FINAL DESIGN REPORT FOR SAND CREEK RESTORATION

July 25, 2023

Mixed Flow Analysis for GSB Design

Sub-critical flow analysis for Shear/Velocity evaluation of Naturalized Channel Design

SAND CREEK RESTORATION WORK MAP

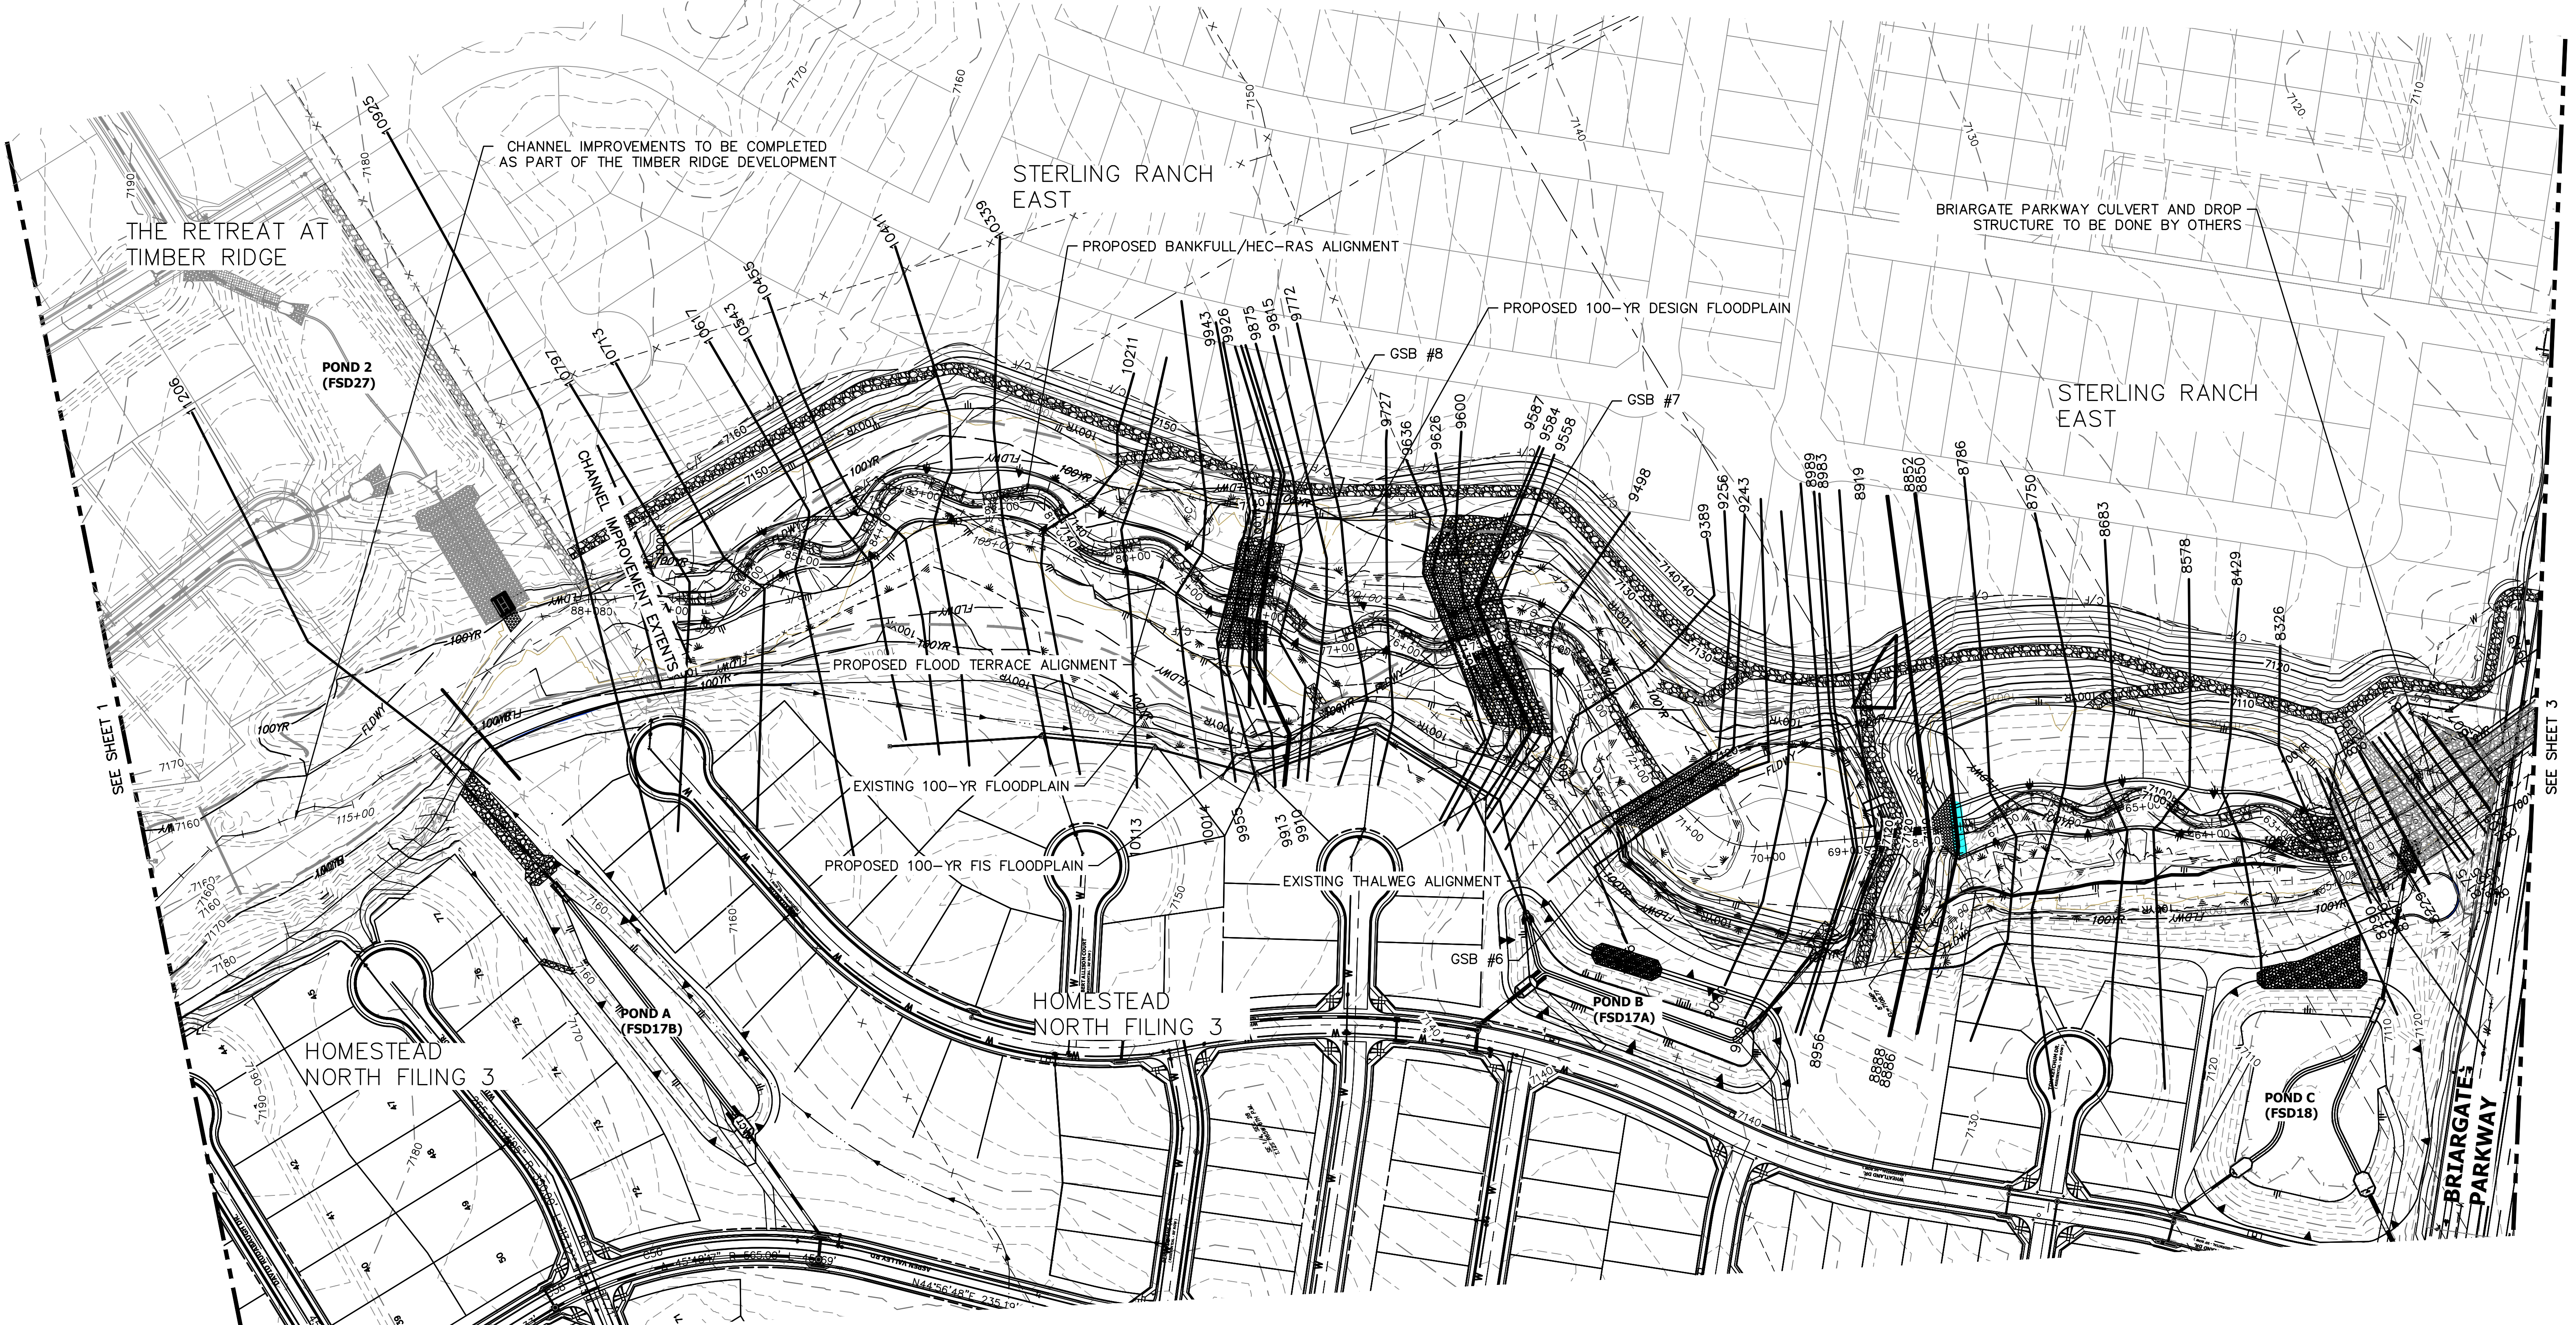
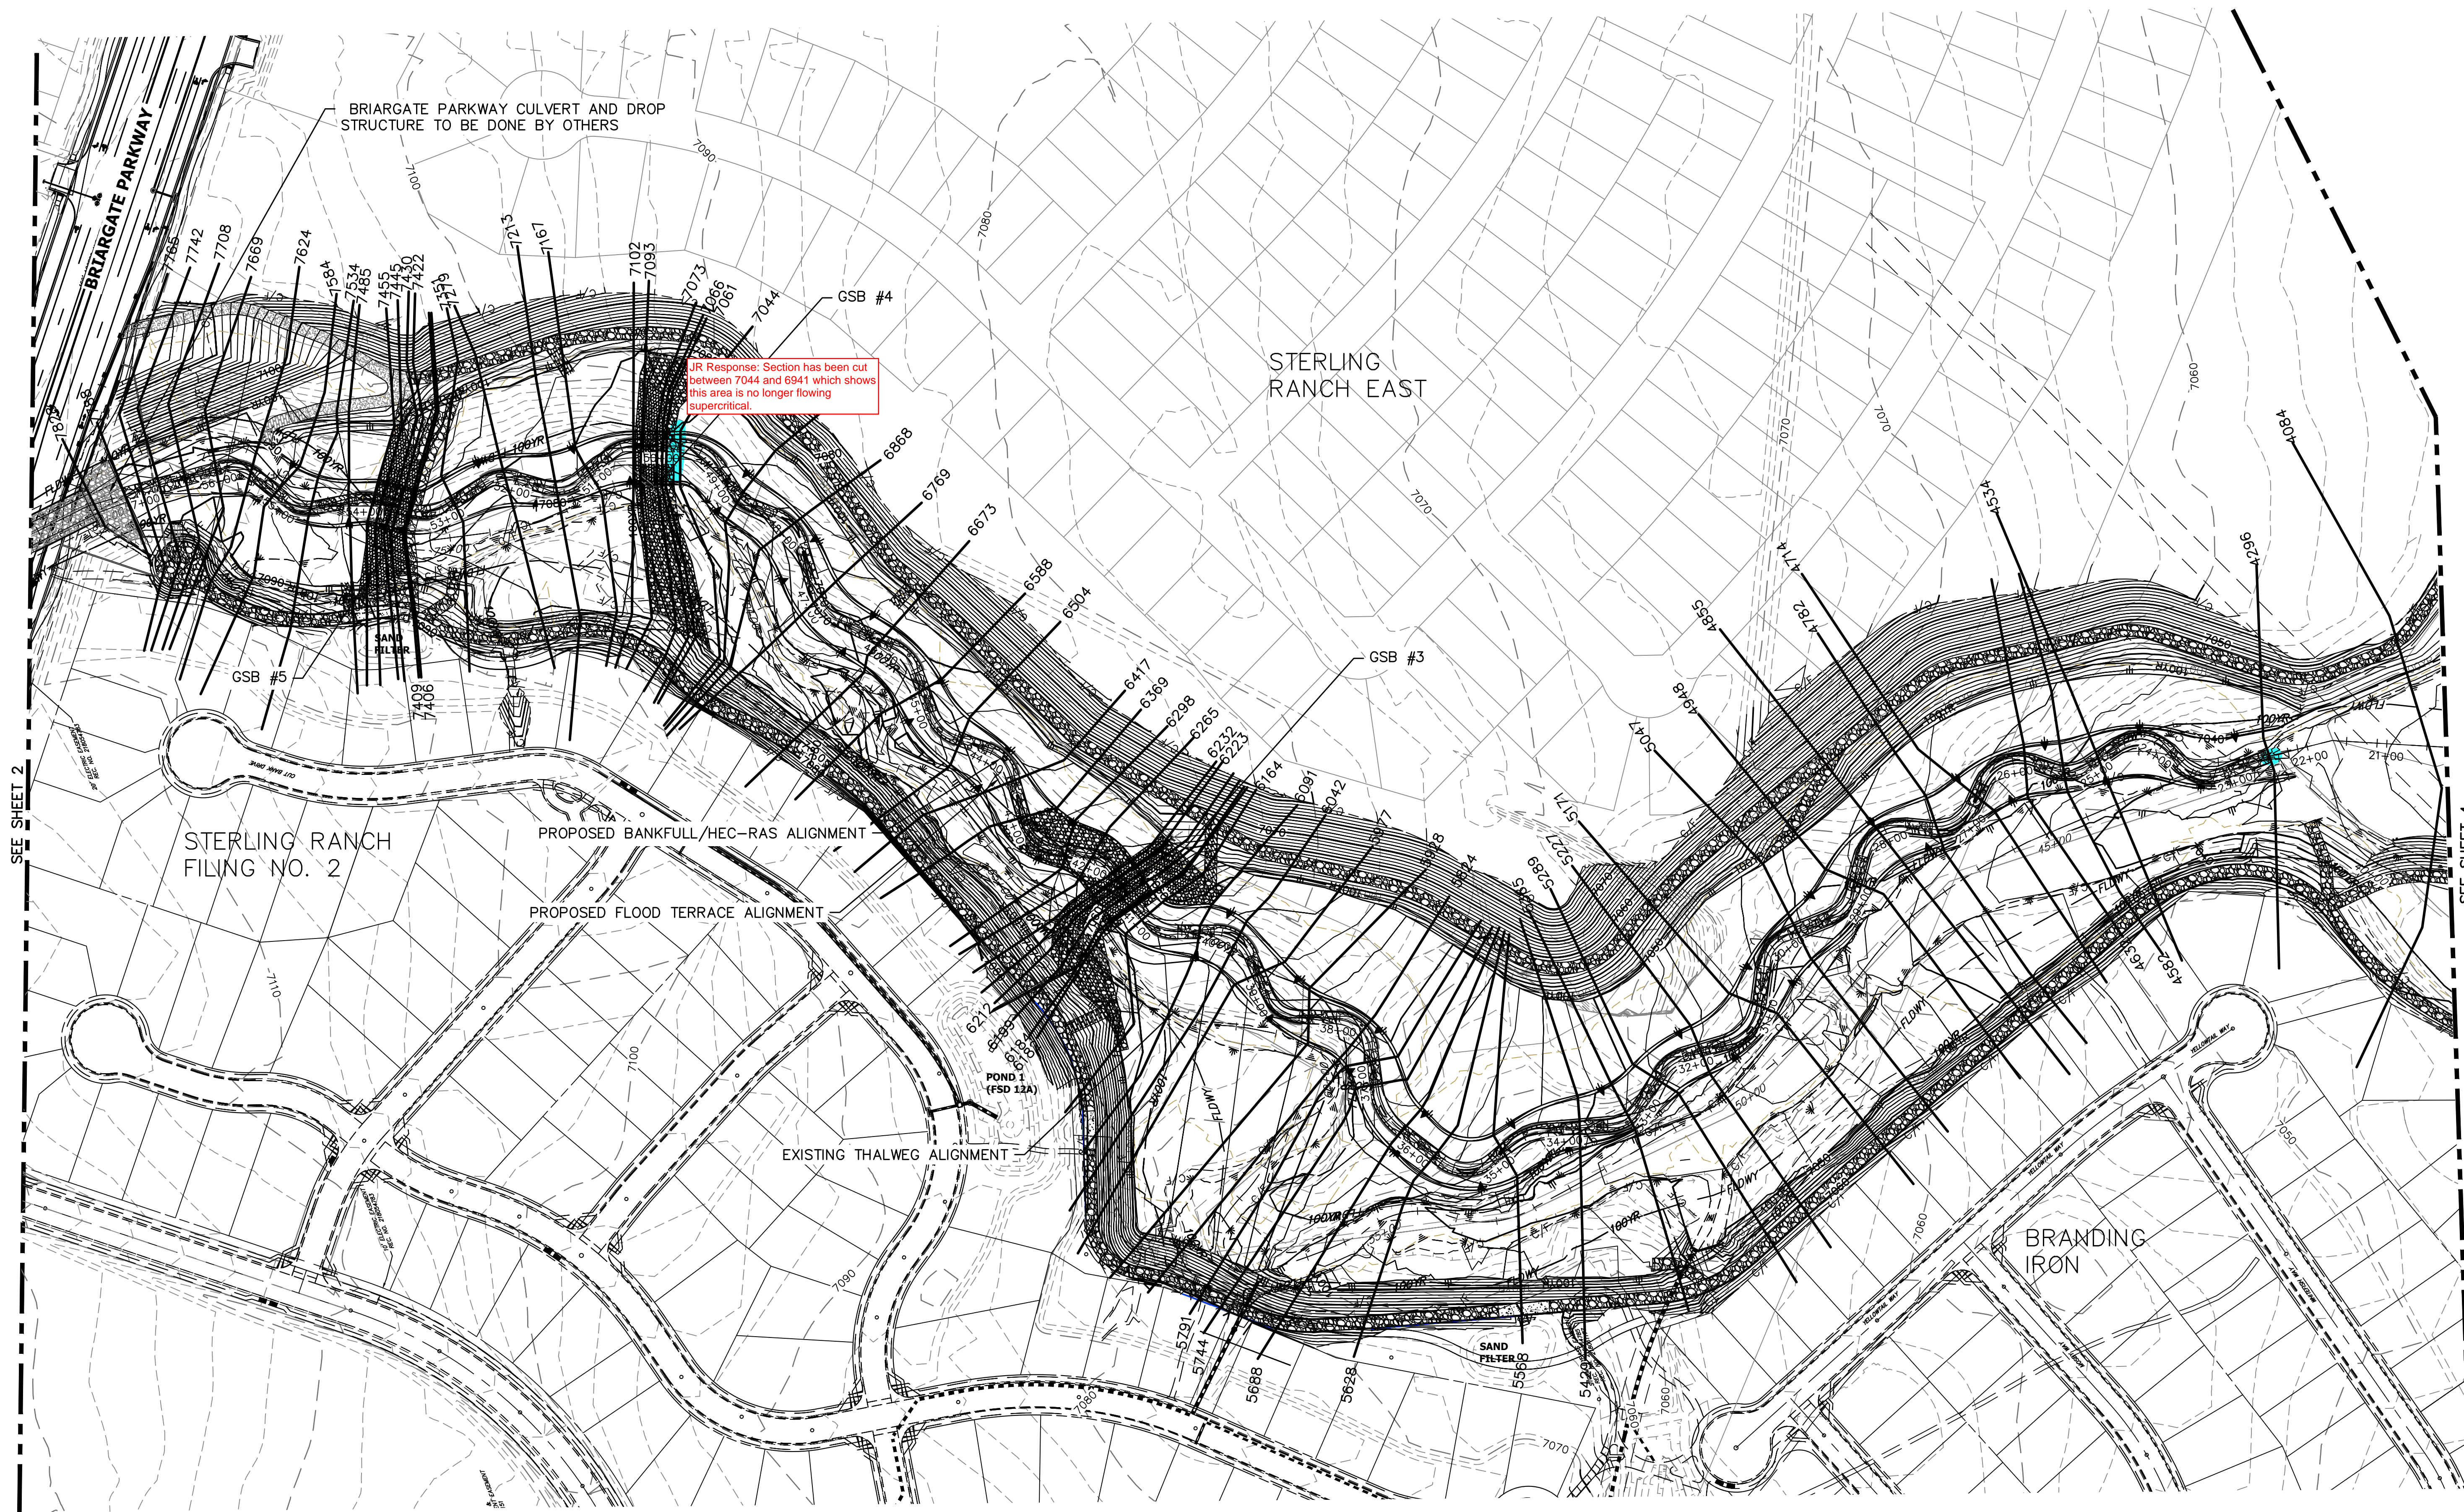
JR Response: Line has been frozen.
Is this a check structure?
